Heckington Fen Solar Park

EN010123

Change Application Cover Letter

Change Application (our document reference – PreExA.CL.CA.v1)

Drawing file: EN010123 / EN010123-000564-Pre-ExA.ChangeApp.ESFIG4.26.V1 - ES Figure 4.26 400kV Bicker Fen NG Substation Layout and Section Details - Rev 2.pdf

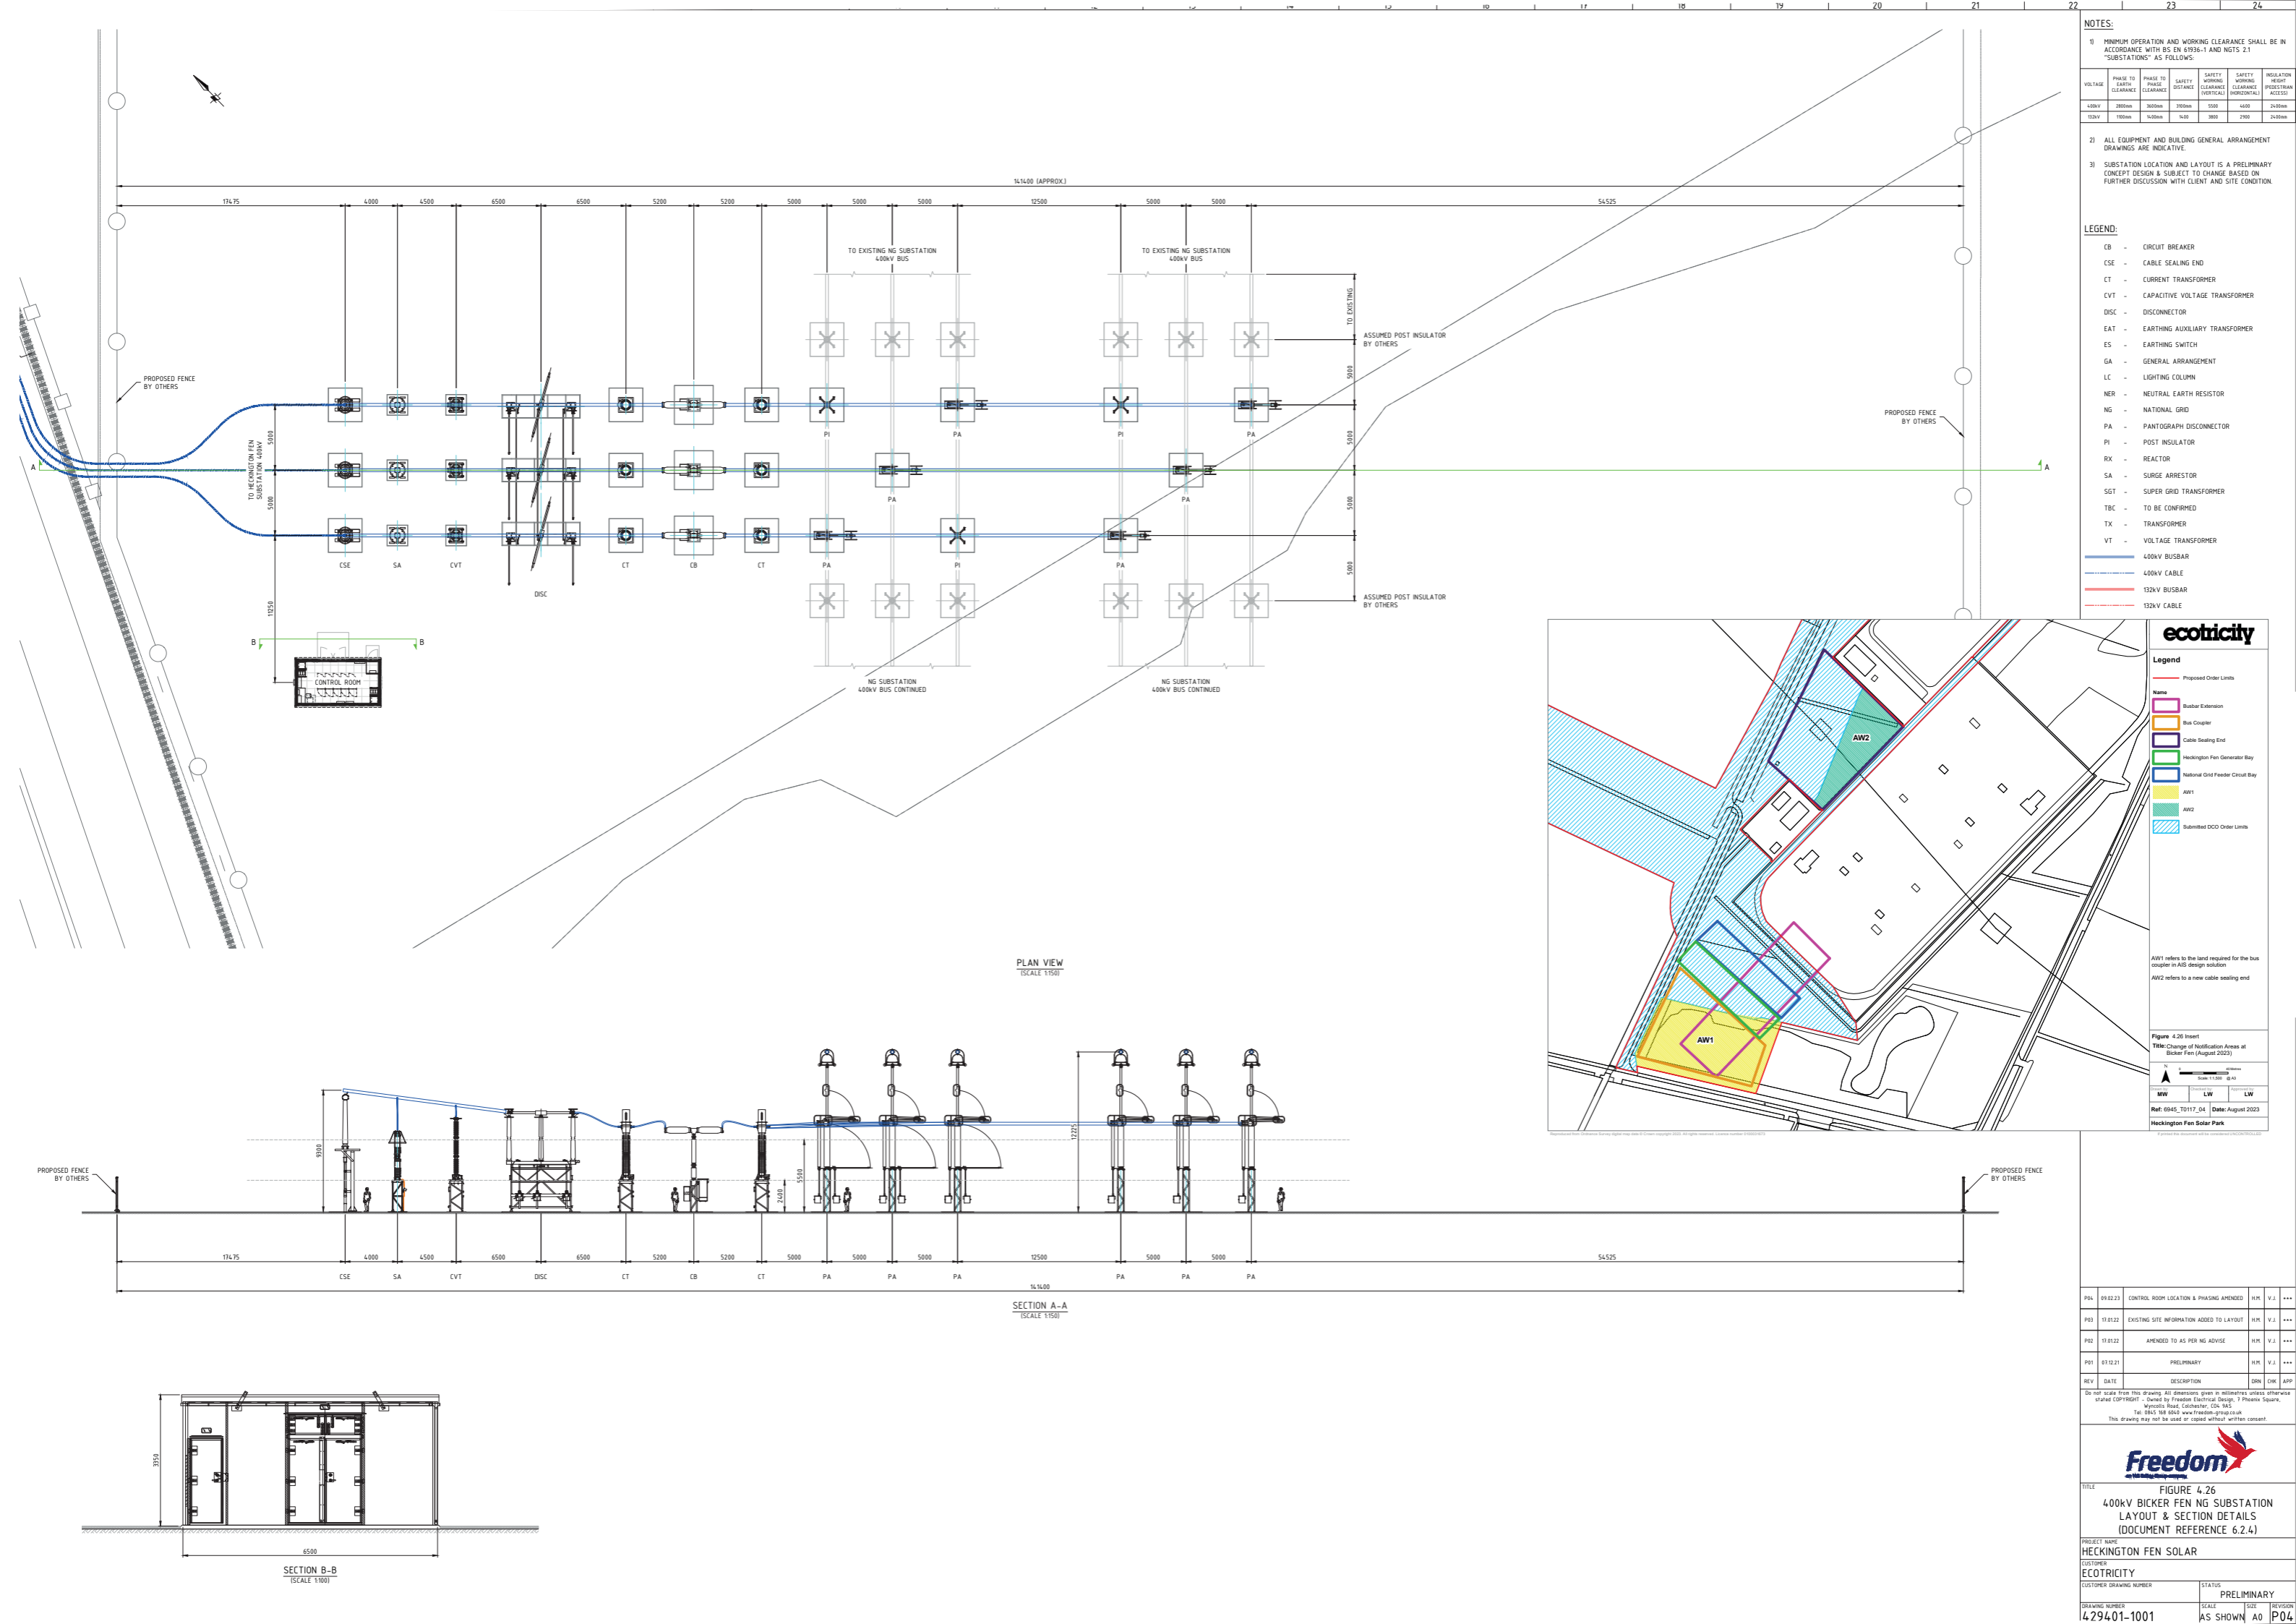
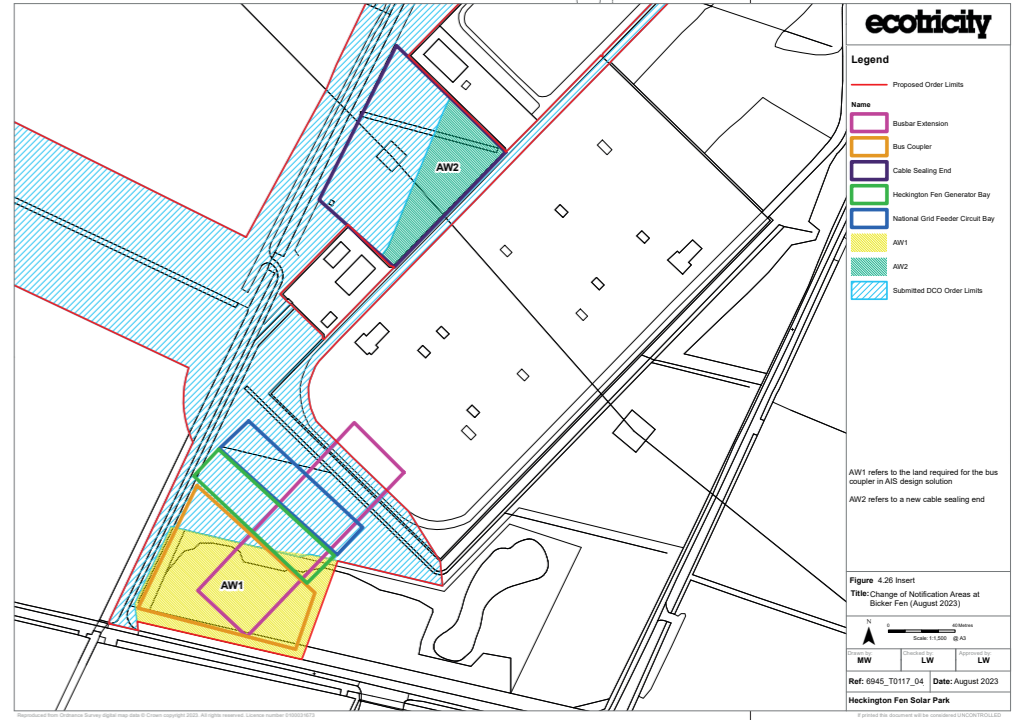
1. a new section of NGET infrastructure at the Bicker Fen Substation comprising a busbar extension including a section breaker, a bus coupler and a feeder circuit on land to the south of Bicker Fen Substation, which is owned by NGET; and

The latest discussions with NGET confirm that additional works needed at the NGET substation are triggered by the Applicant's Proposed Development; these works include a new section of NGET infrastructure to be built to ensure compliance with the infeed loss risk at Bicker Fen Substation. A complete substation section comprises:

1. a busbar extension and a bus section circuit breaker²;
2. a bus coupler³; and
3. at least one feeder circuit⁴ to evacuate power.
